Department of Transportation

April 21, 2023

RE: Space Village Rd. Outdoor Storage _ PPR233

SHEET TITLE: **SITE PLAN**

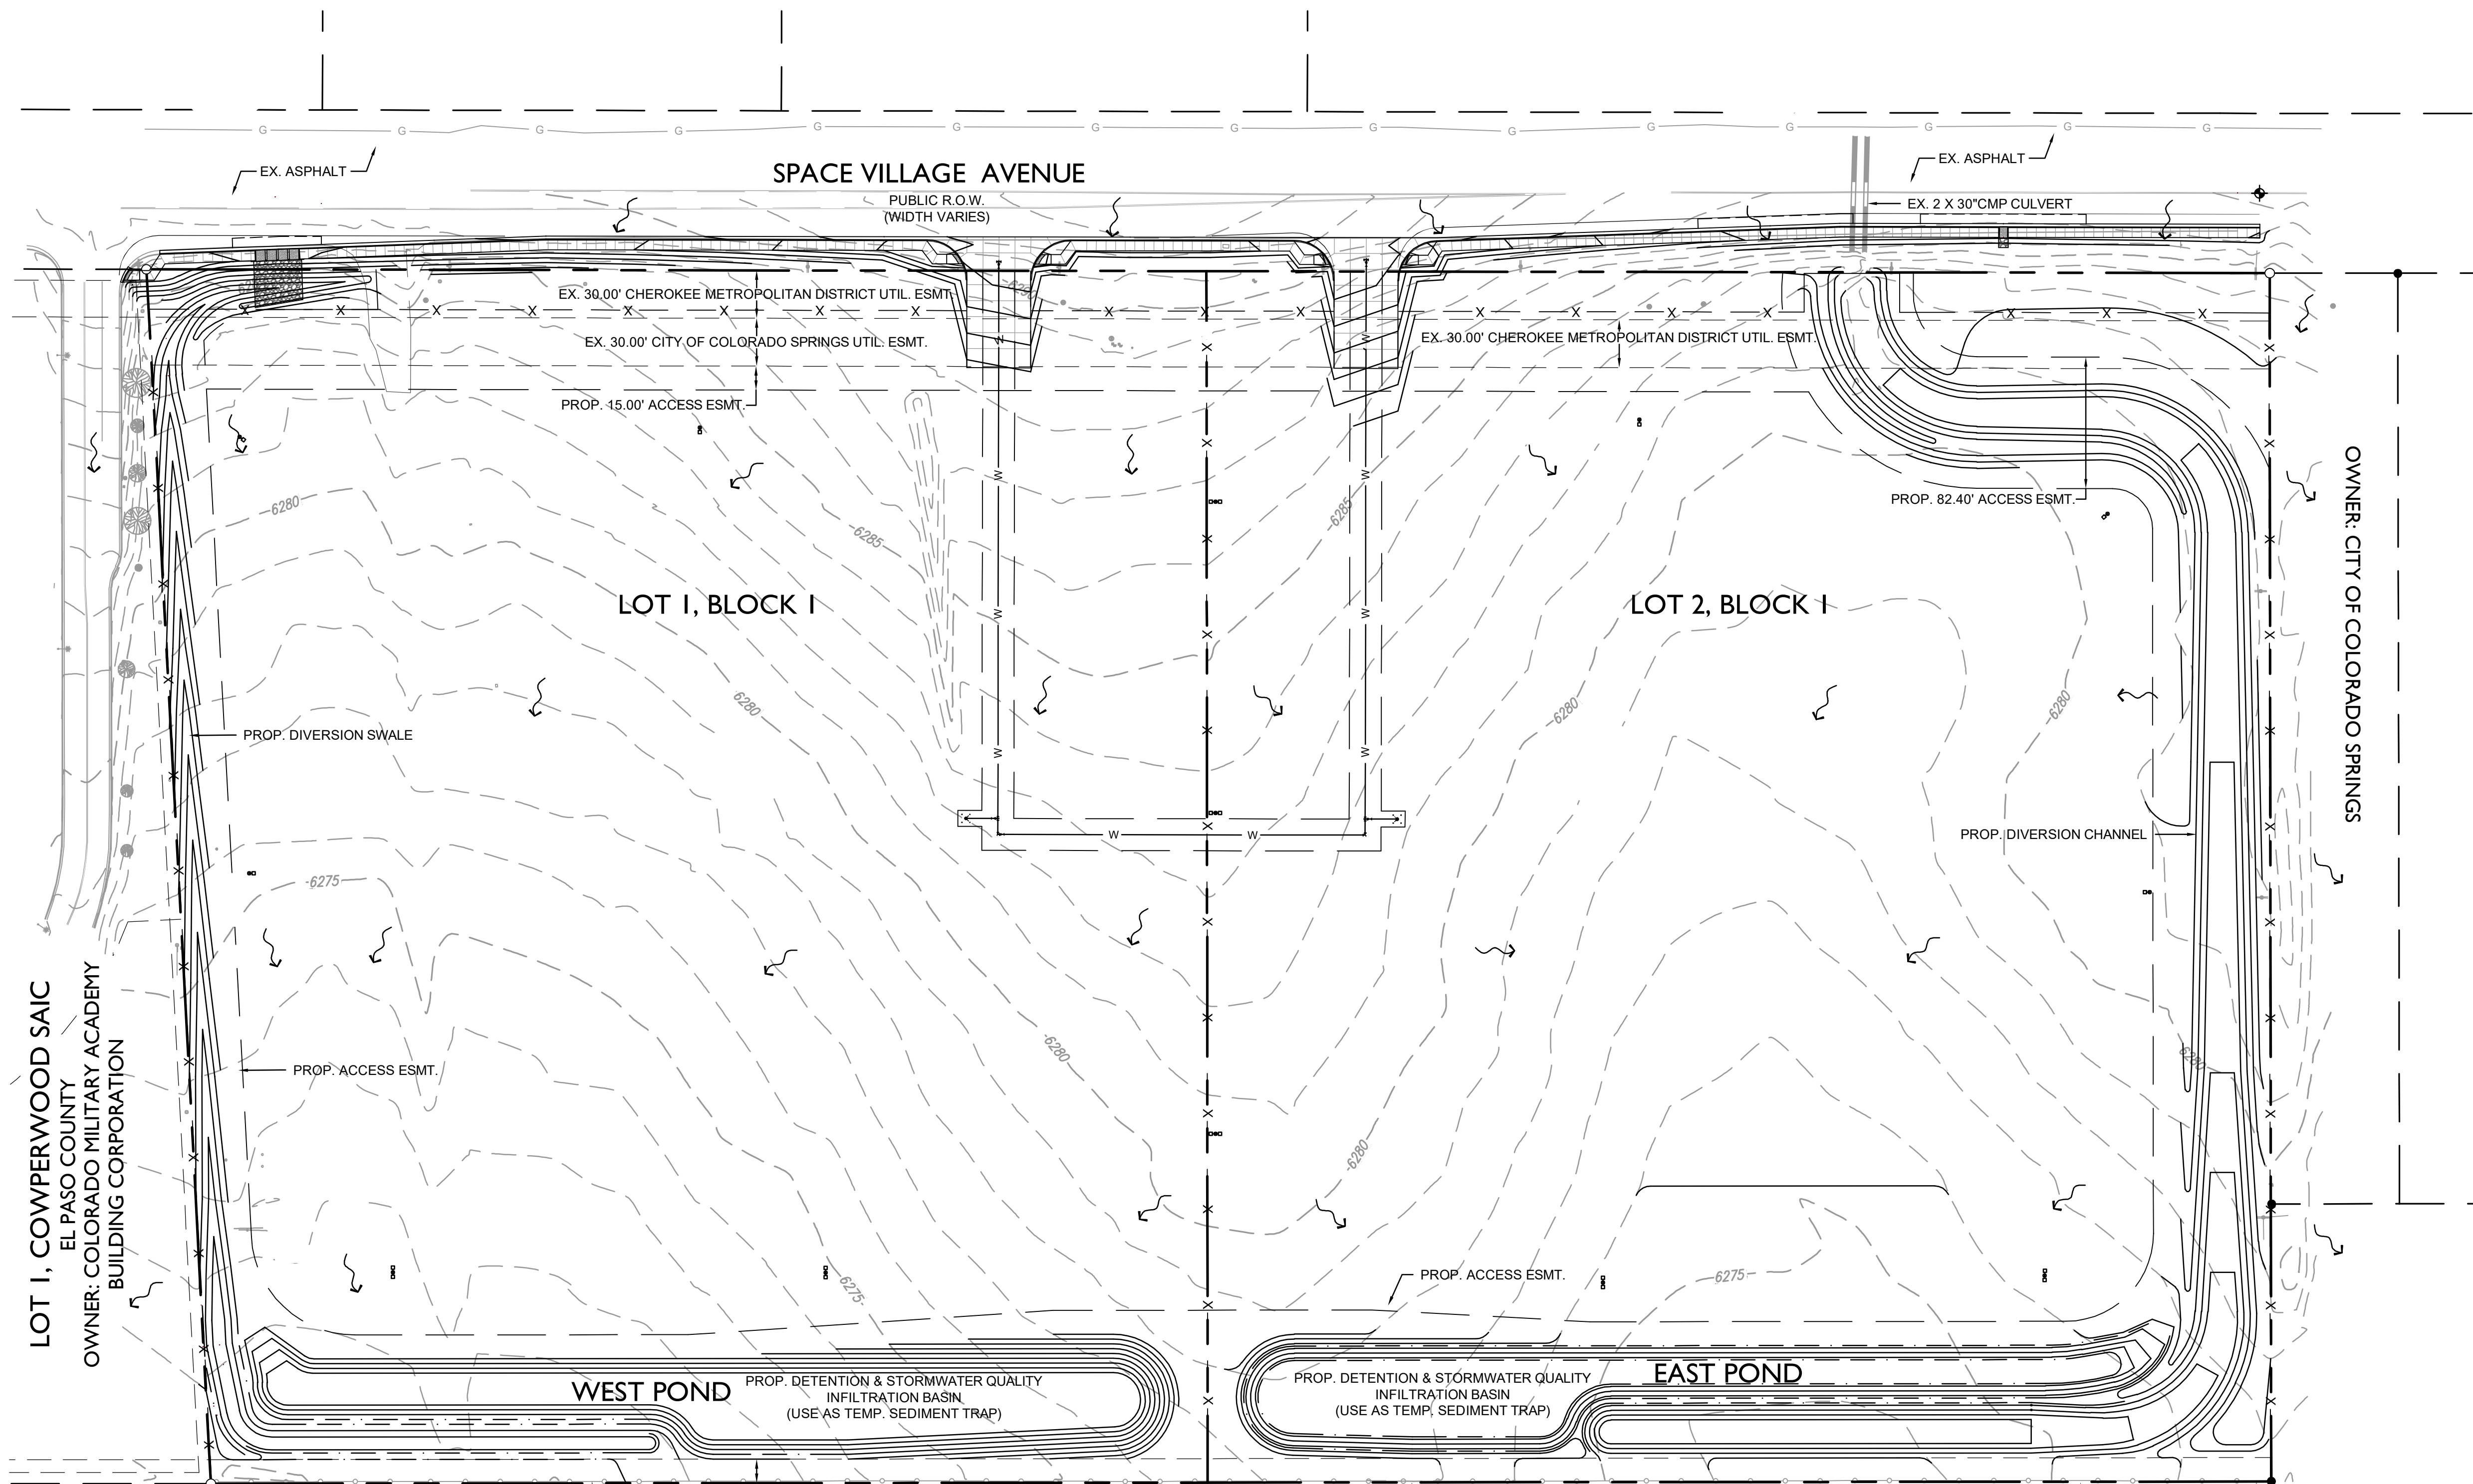
- CDOT Traffic recommends that the proposed east access point line up with the access to Storage Sense that is on the northside of Space Village. This driveway placement would eliminate a potential overlapping left between the two driveways.
